PLOT PLAN DRAWING CHECKLIST

PROJECT NAME: Eastholme of the Rockies B&B 4445 Hagerman Ave
SUBMITTAL DATE: 4/2/17
SUBMITTED BY: Susan Taylor
SUBMITTAL REVIEWED BY: _____

Special Use Plot Plan

Susan & Kevin Taylor
Eastholme of the Rockies
Bed and Breakfast
4445 Hagerman Ave
Cascade CO 80809

## Special Use Plot Plan

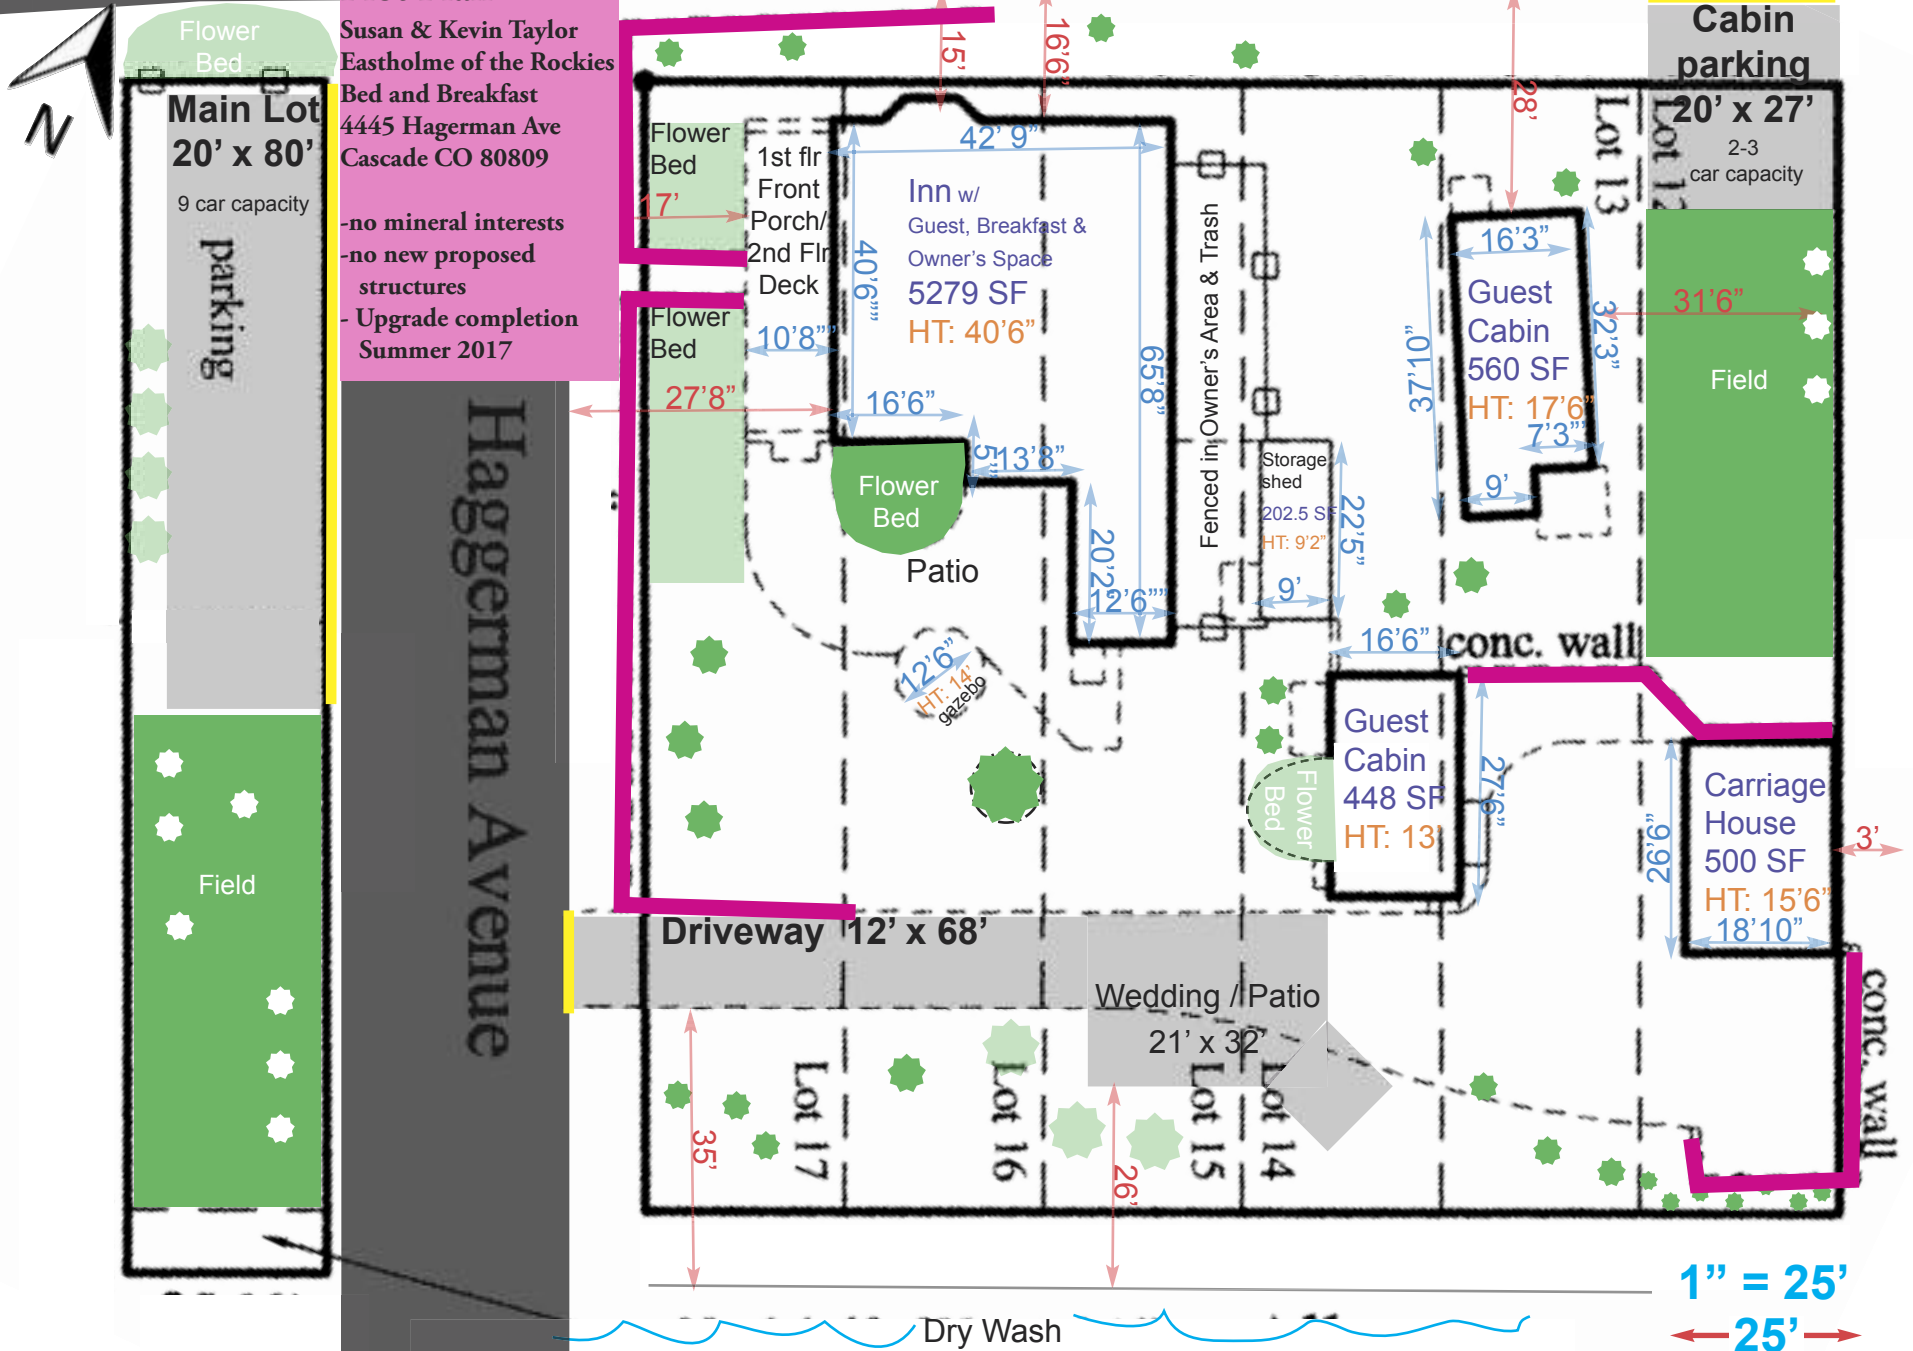
The site plan should have a north arrow and a line under the scale to represent one inch.
